Subject: RE: Land at Charlcrafft Lane, Bersted (our ref: 7216) - BE/81/20/OUT

Environment Officer
Environmental Protection
Chichester District Council

PLAN ECO3
Protected Species

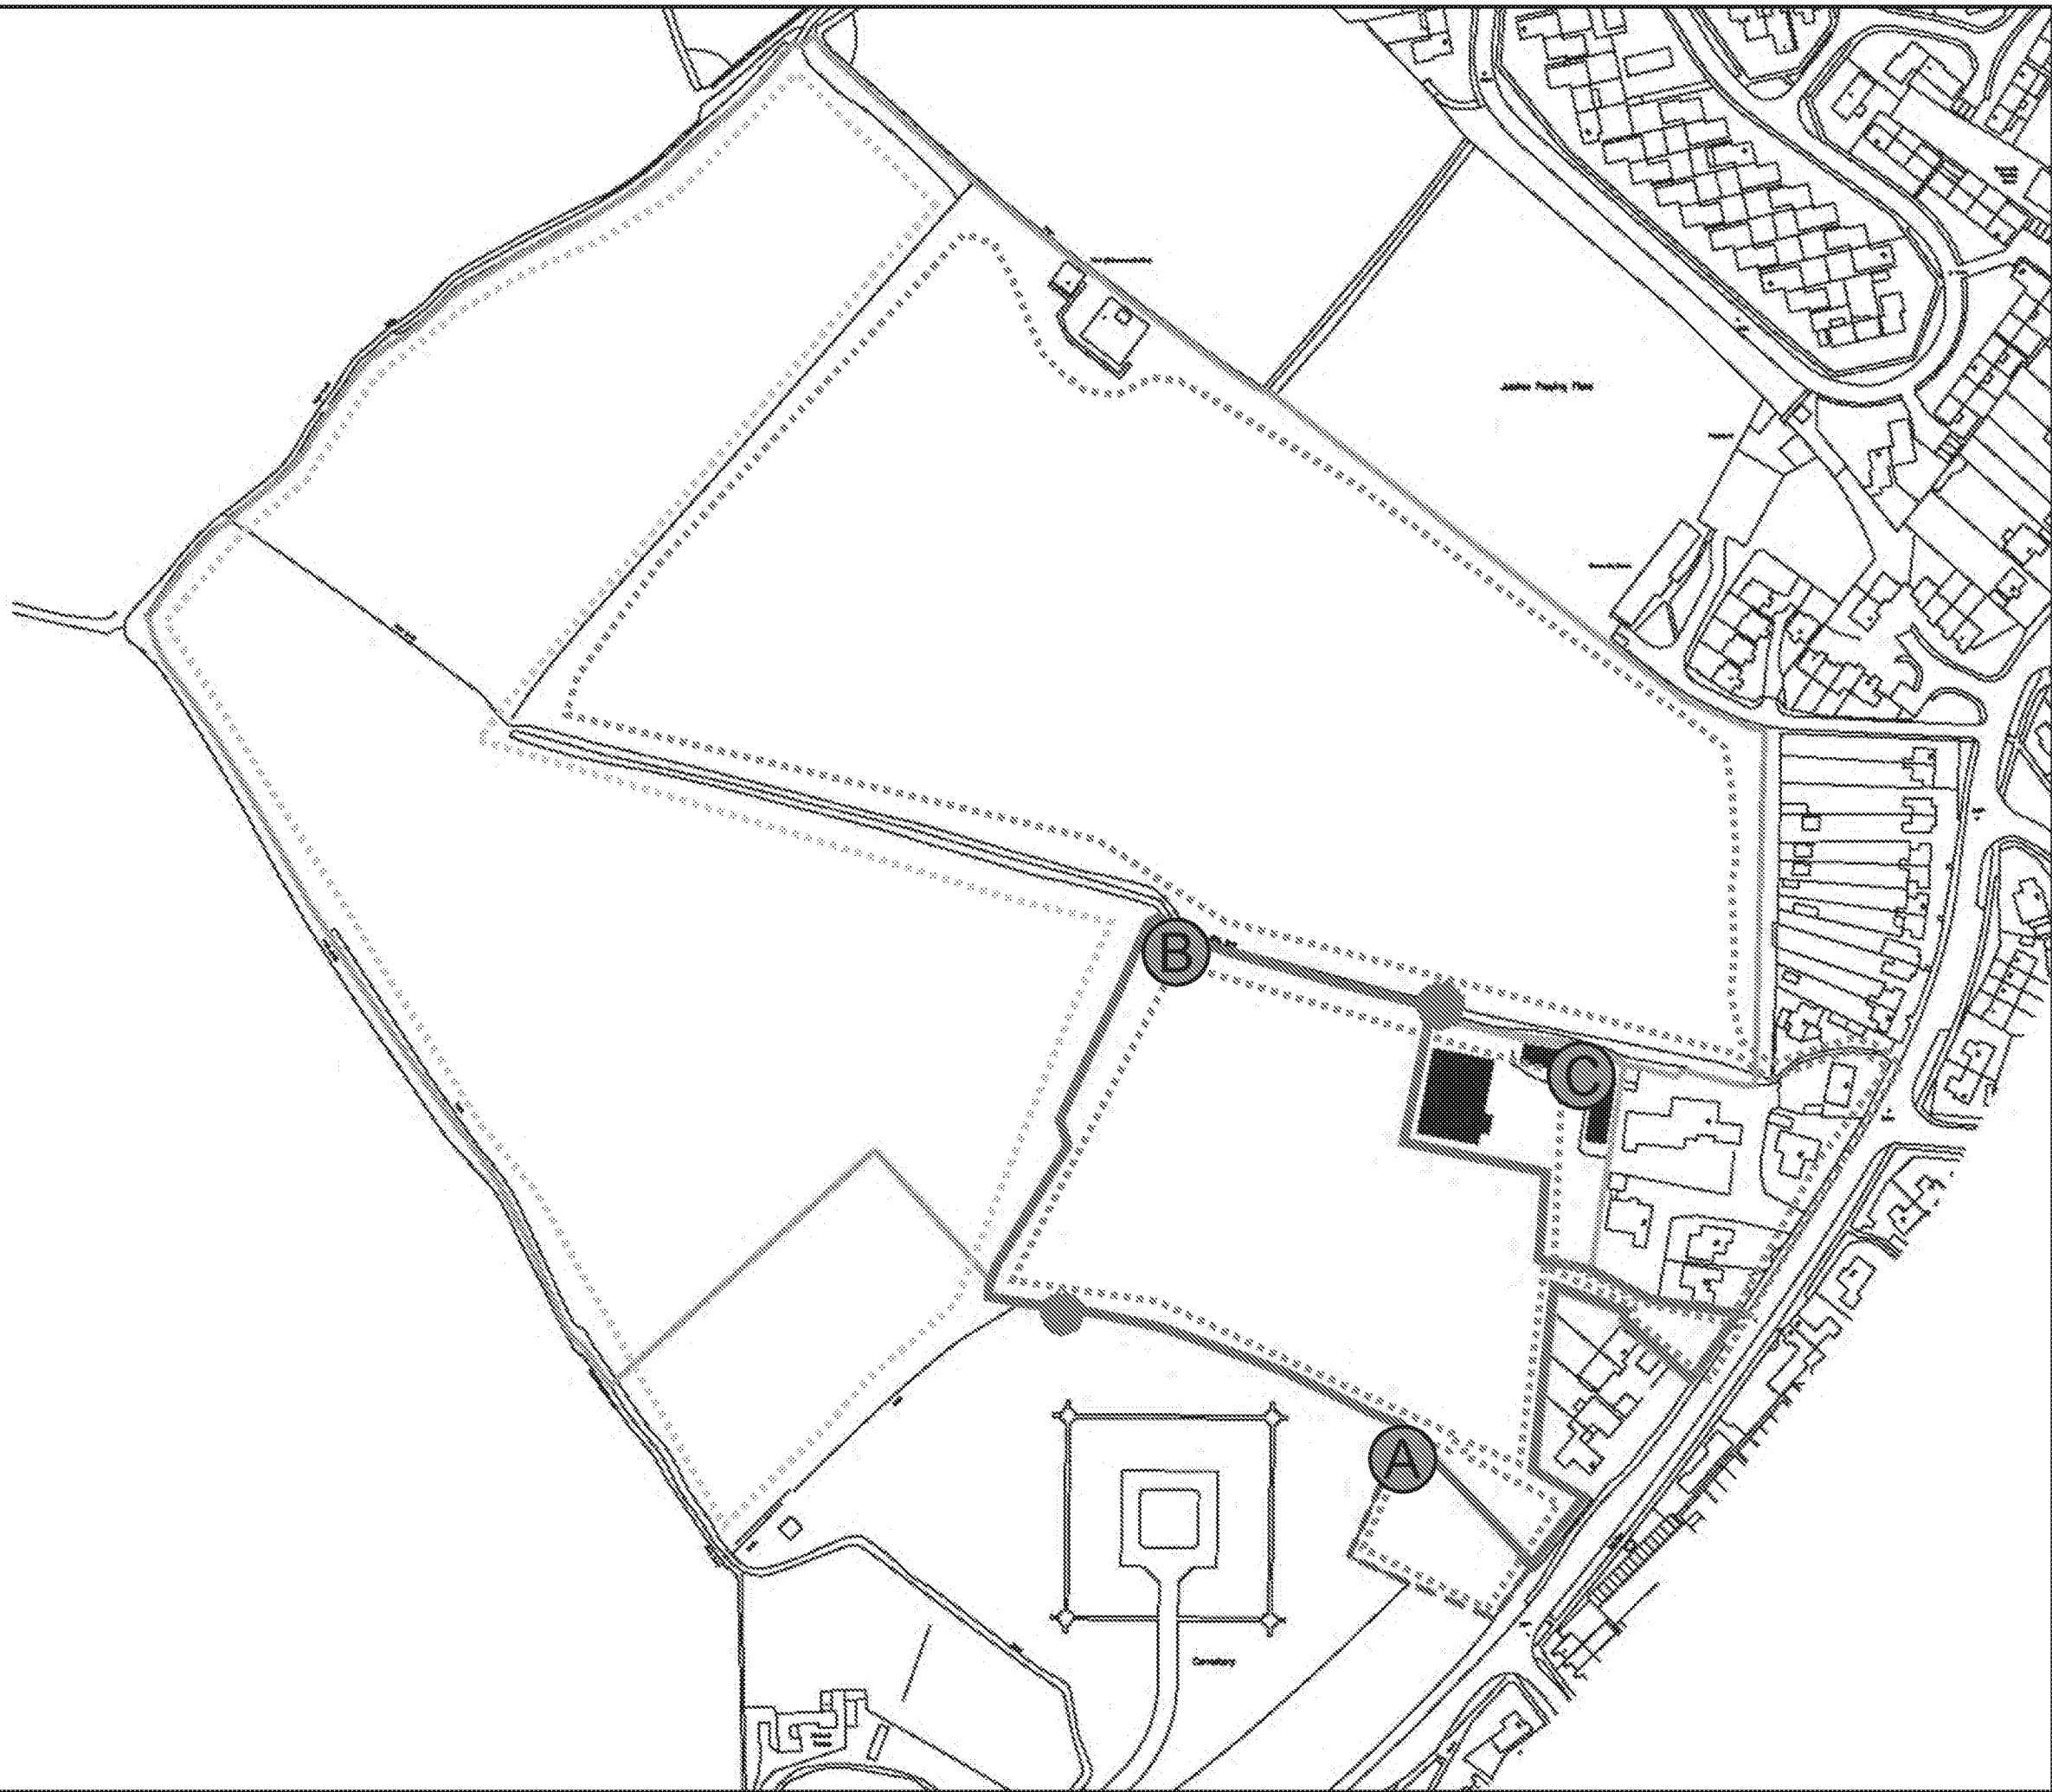
Yes we would want a bat survey done at outline ideally. The EIA assessed the site as a whole and identified that there was potential for bats in two trees. IF these trees are being retained then no further survey work is needed, but if they are being removed pruned etc a survey is needed. Ideally we don't like surveys conditioned, but if they still don't know if the trees are being removed it could be conditioned at this stage but at reserve matters the survey and any mitigation required would need to be provided if the trees were being removed.
